TOWN AND COUNTRY PLANNING ACT 1990

FULL

Reference:	H14-0205-18	Date of Decision:	1st May 2018
Applicant:	Ms T Rodgers Claydon North Drove Spalding Lincs PE11 3JF		
Location:	Claydon North Drove Spalding		
Description:	Proposed one-and-a-half storey dwelling

Drawing No. : TR/ND/101 Revision :

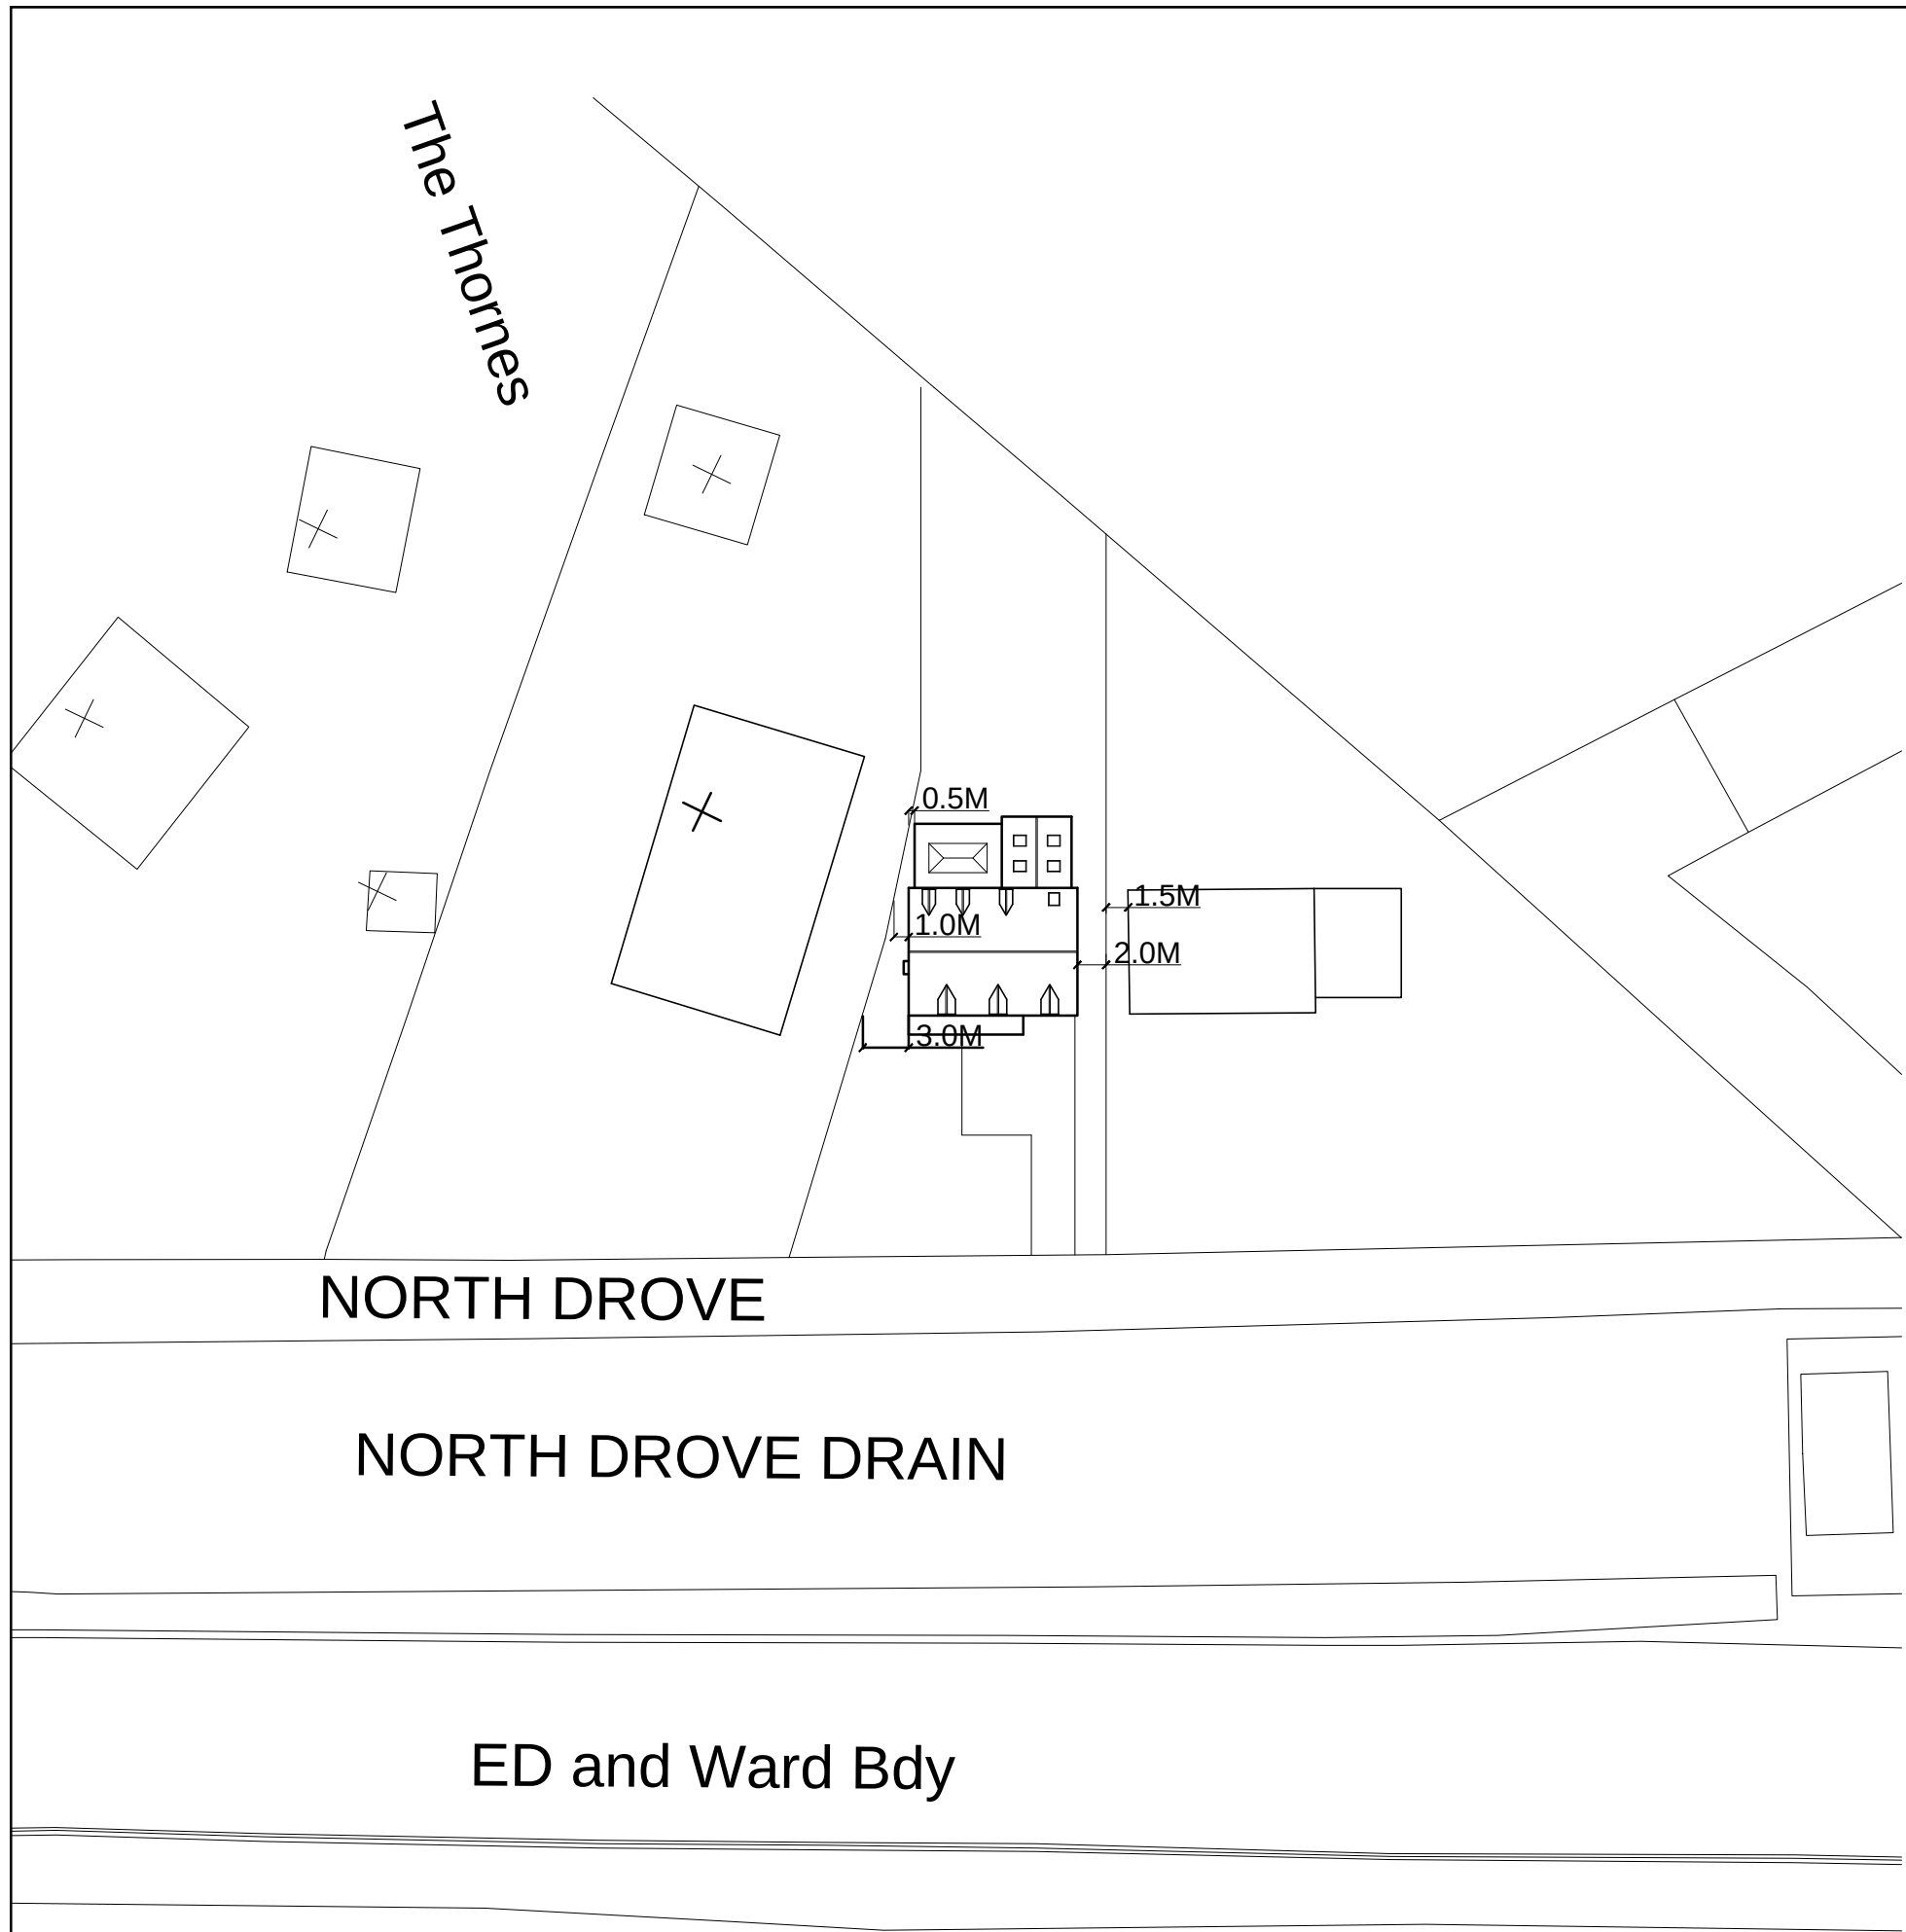
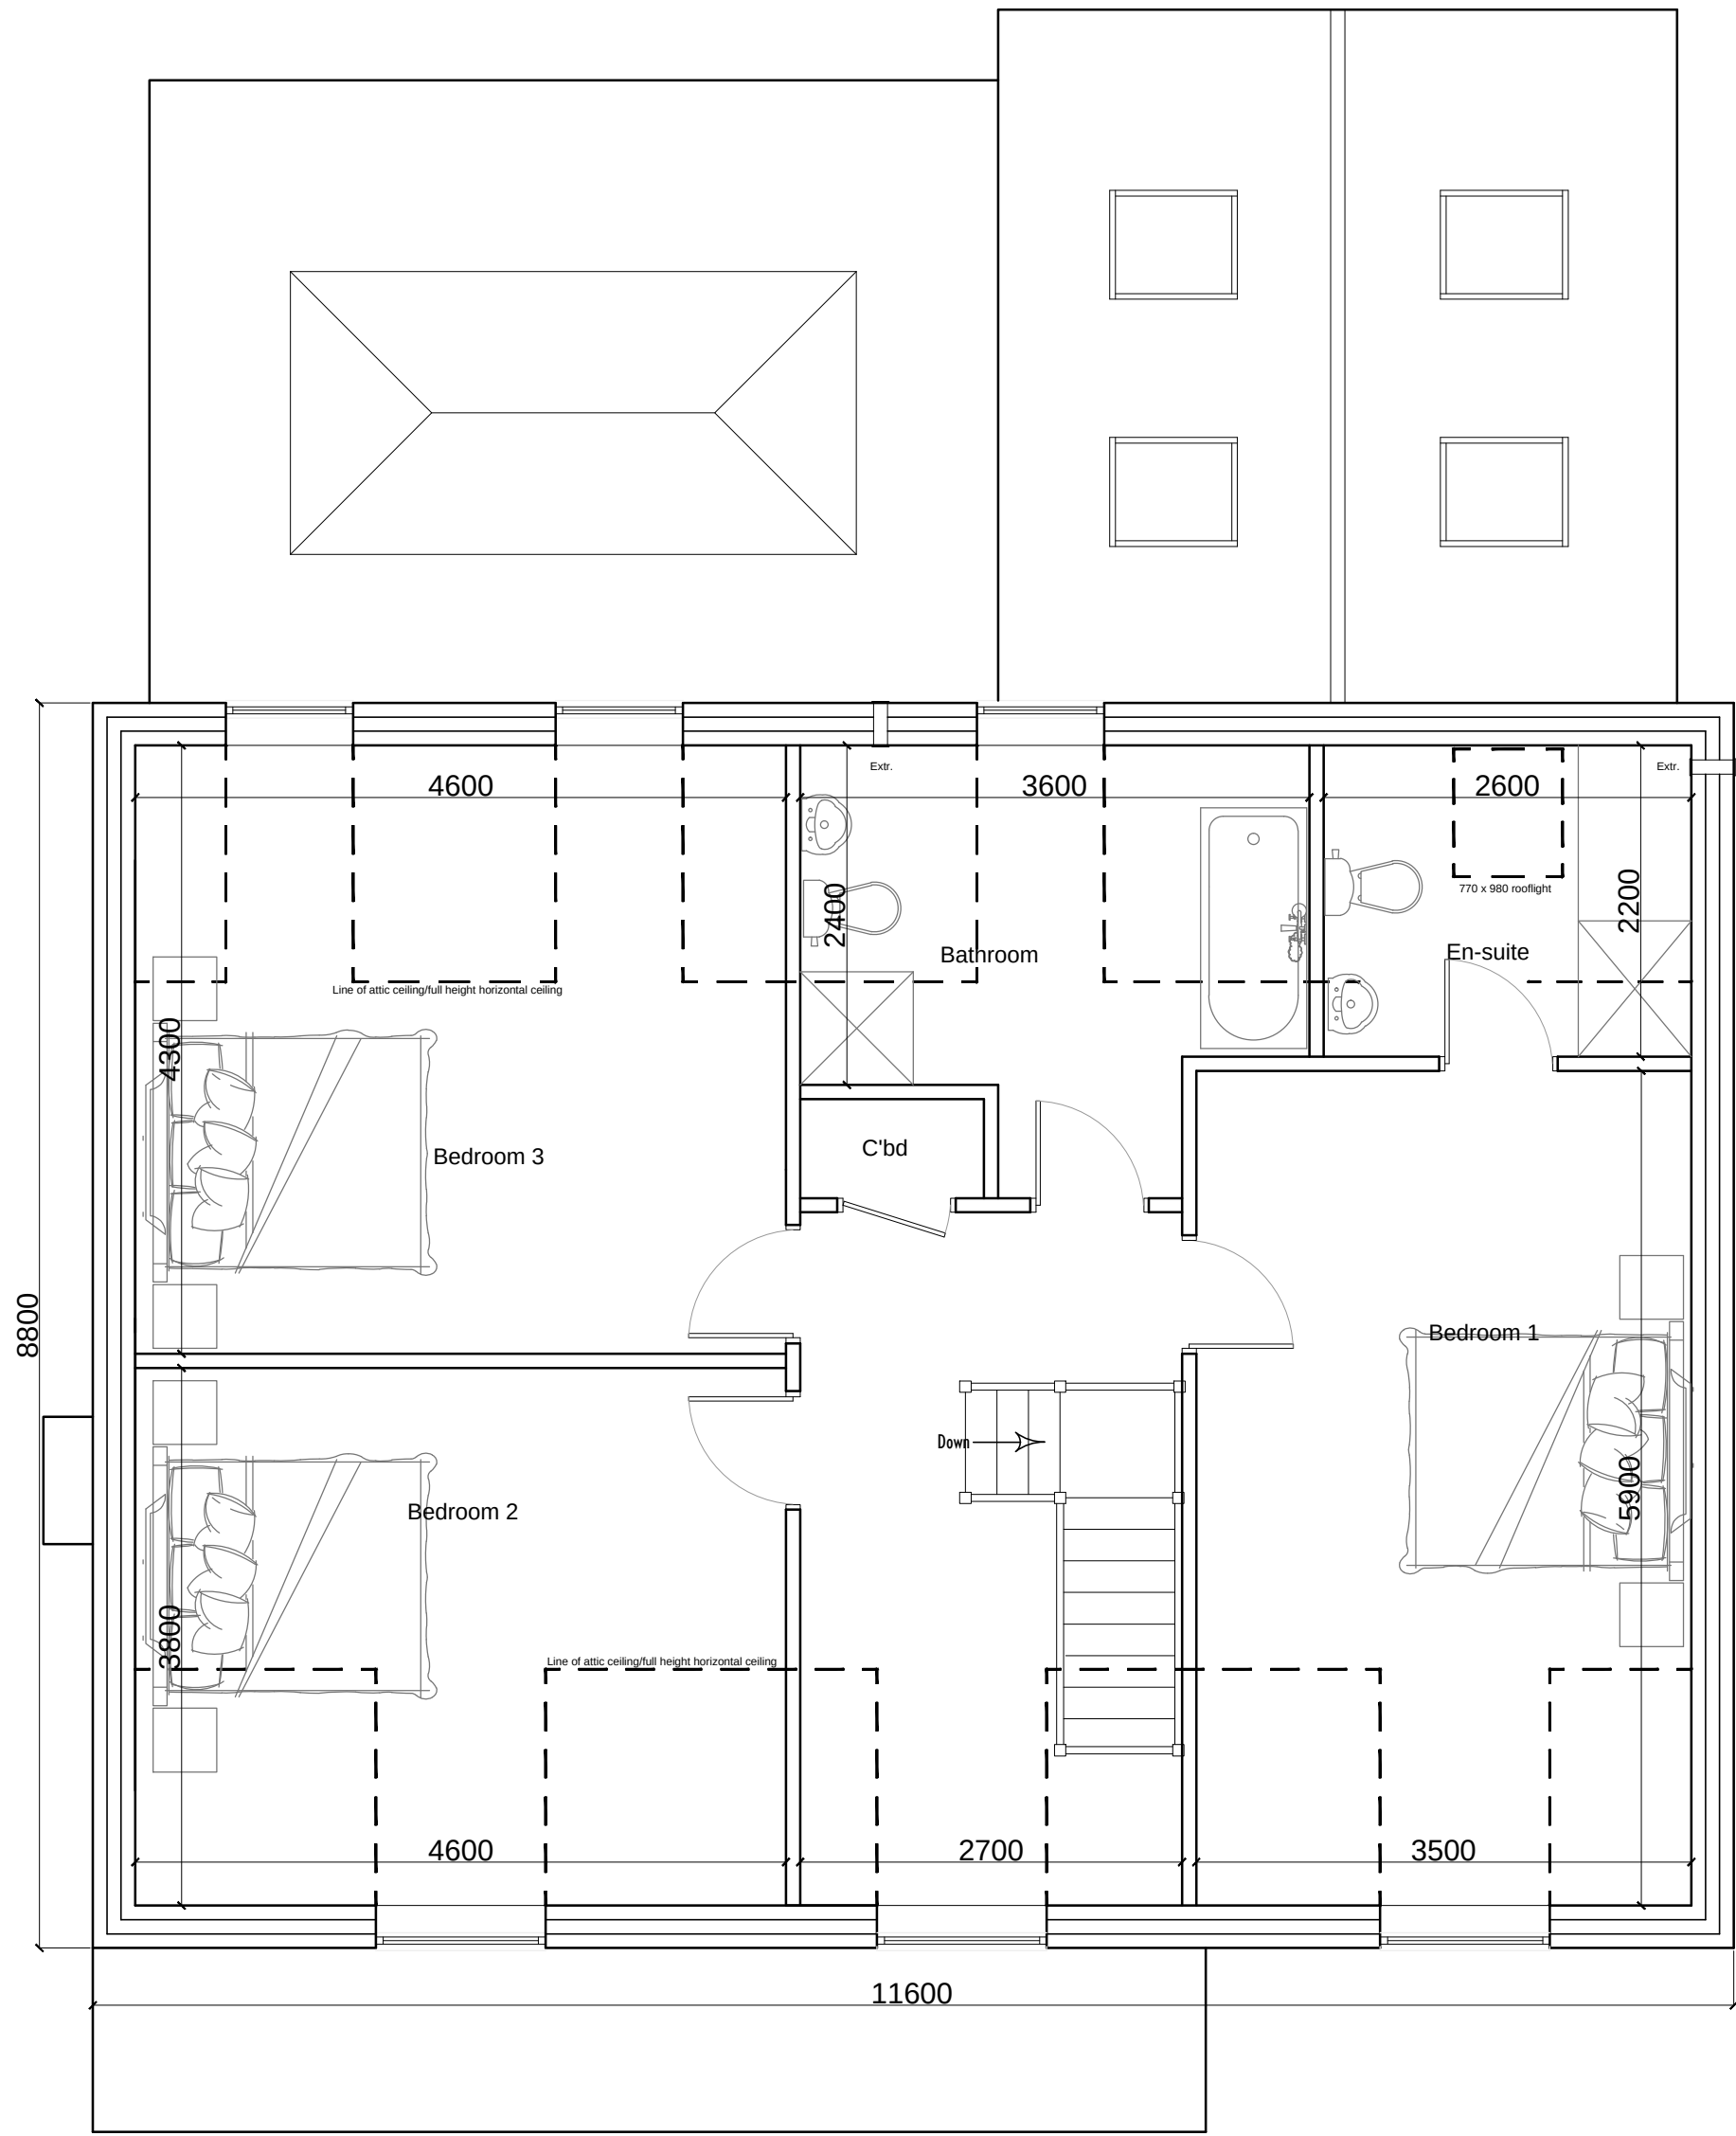
- 2 The proposed development is considered to be a cramped form of development which is at odds with the character of existing development in the locality.
